**Subject:** 2023/90668 Erection of B2/B8 Industrial Unit and associated works Grange Moor Coachworks, Barnsley Road, Grange Moor

**2023/90668 Erection of B2/B8 Industrial Unit and associated works Grange Moor Coachworks, Barnsley Road, Grange Moor, Huddersfield**

The WYAAS have reviewed the application for the demolition of the current coachworks site and construction of a new B2/B8 industrial unit and associated works.

Landscape Strategy

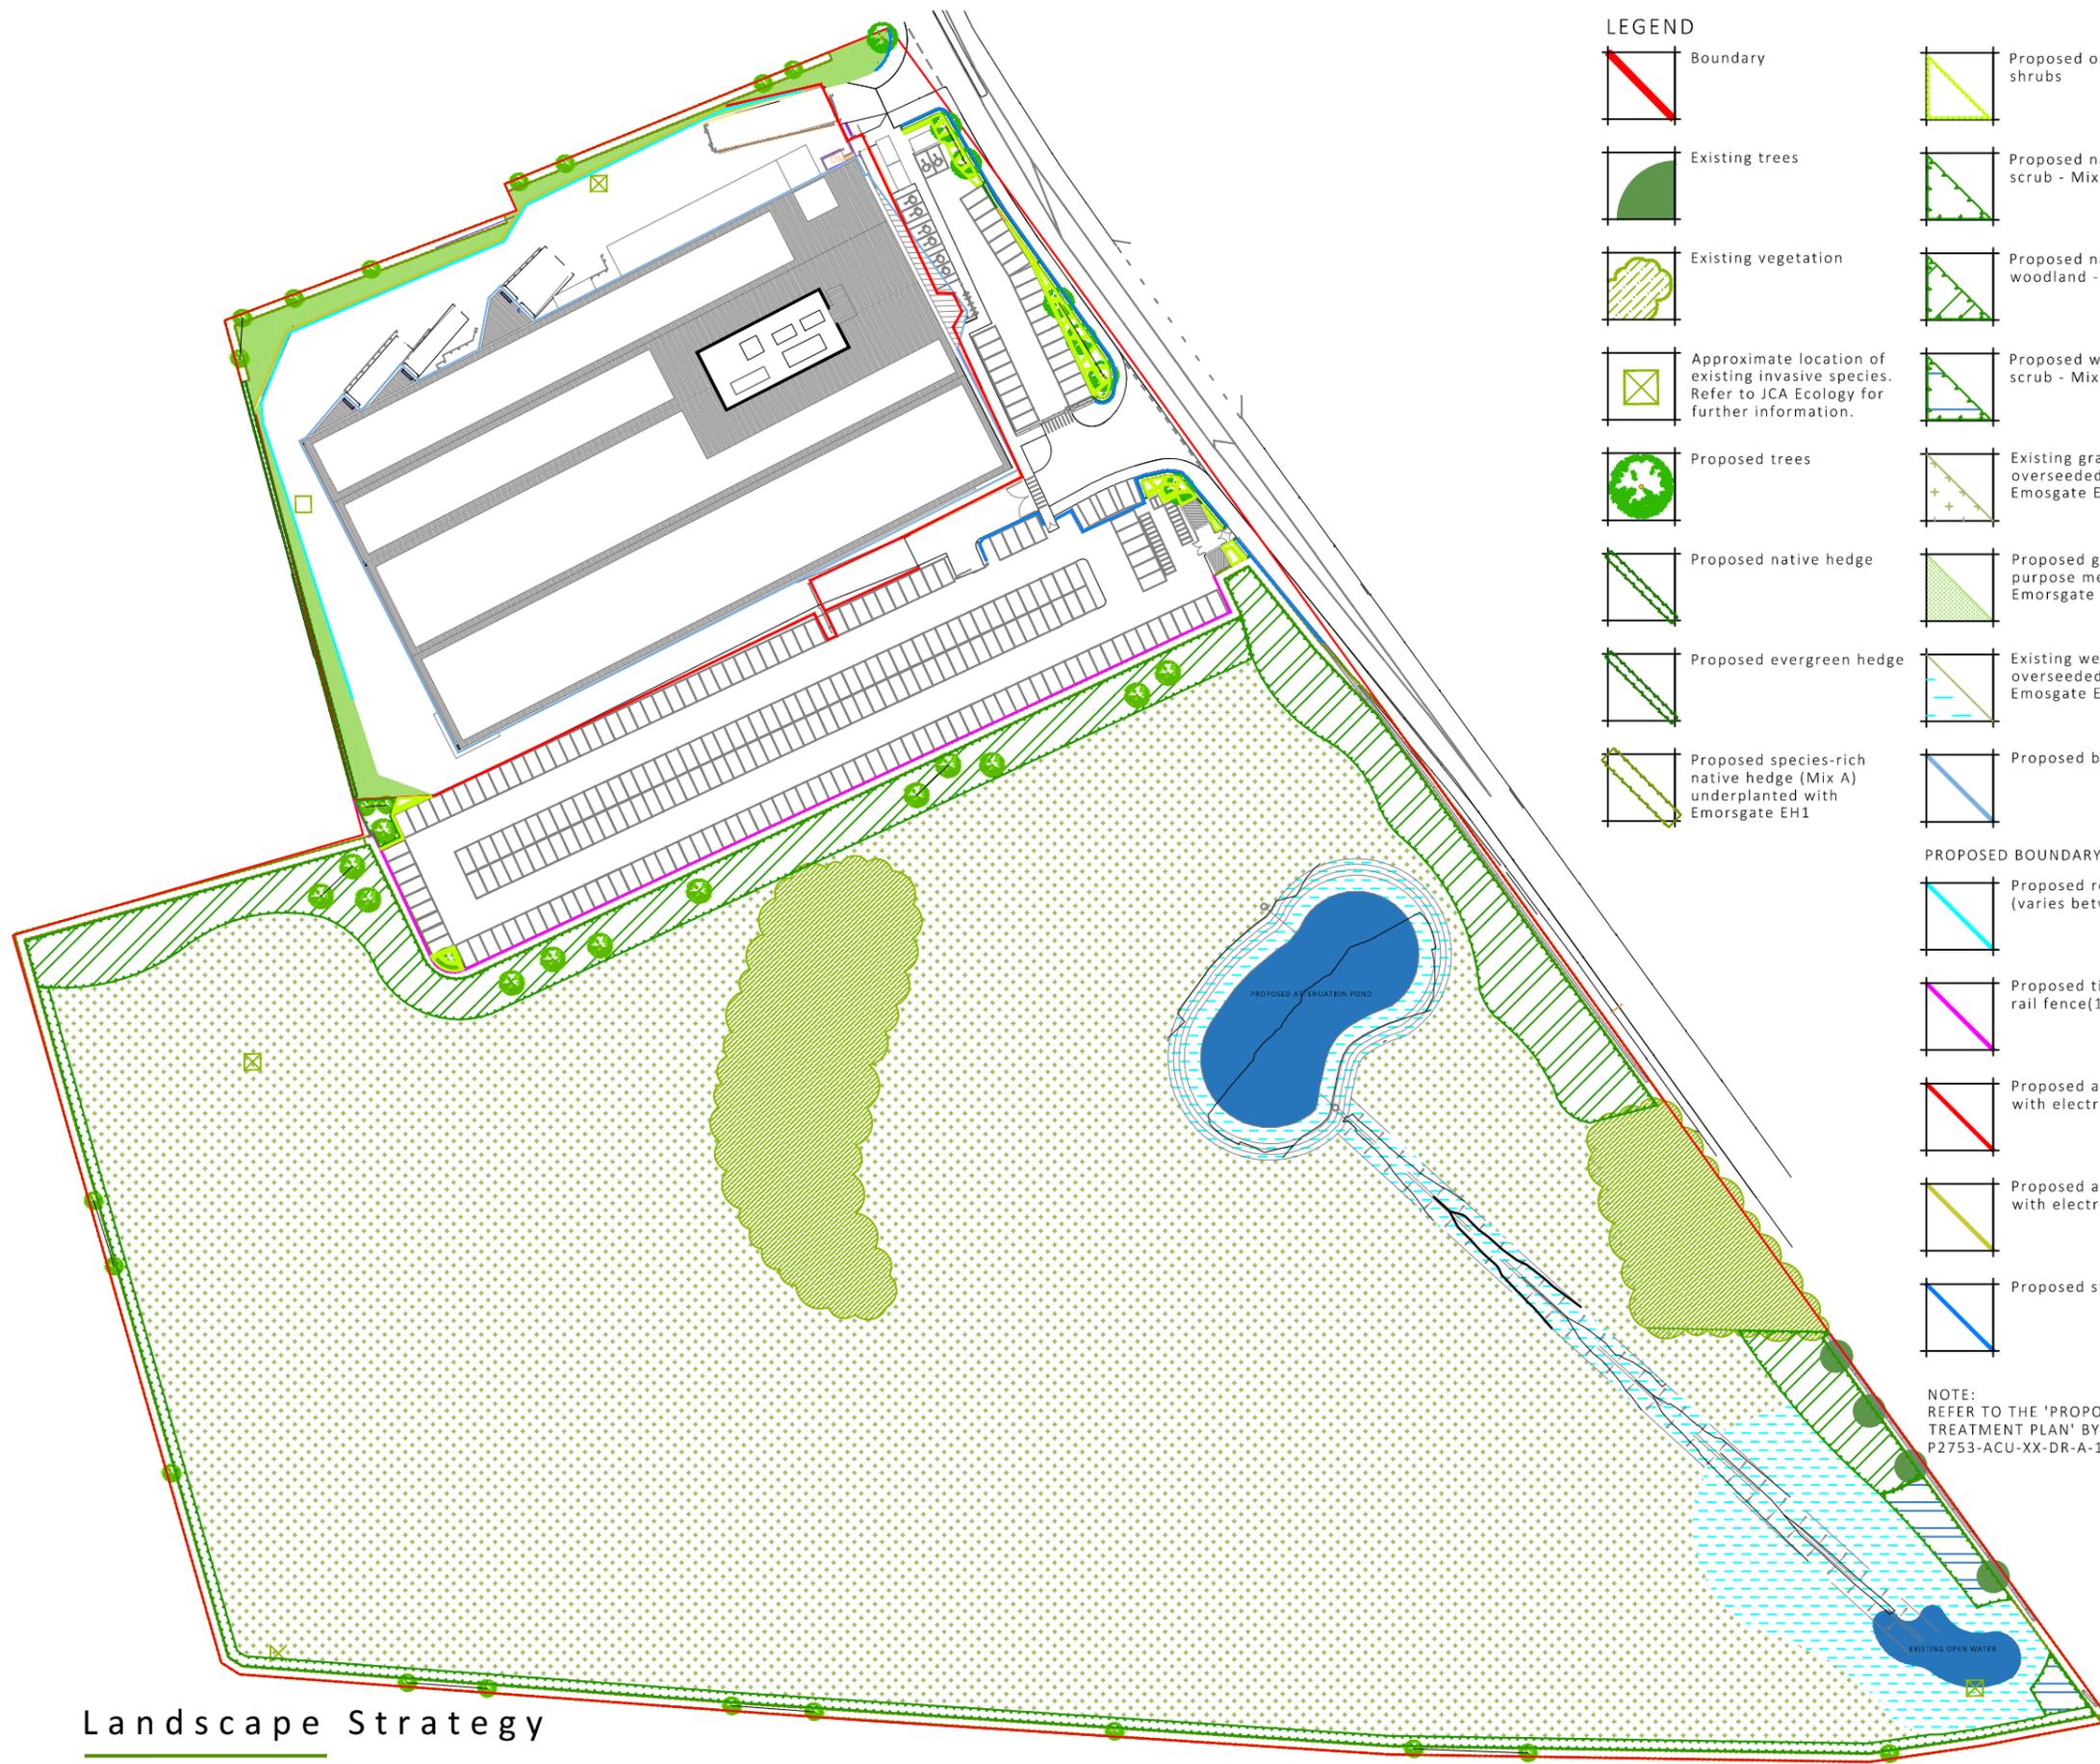
There is therefore the potential for Prehistoric or Roman activity to be present in the field to the south of the proposed surface water balancing pond field and these archaeological features could extend north into the balancing pond field. The proposed works in the balancing pond field are limited but there is the potential to impact on archaeological remains if such remains are present.

Due to the potential for archaeological remains to be present in the field of the proposed balancing pond the West Yorkshire Archaeology Advisory Service would recommend that a programme of archaeological works is undertaken during development, if the development is approved.

Considering the uncertain date and character of the archaeological remains to the south, and the limited nature of the proposed works in the field, it is recommended that an archaeological watching brief should be undertaken on all excavation groundworks in the field of the proposed water balancing pond.
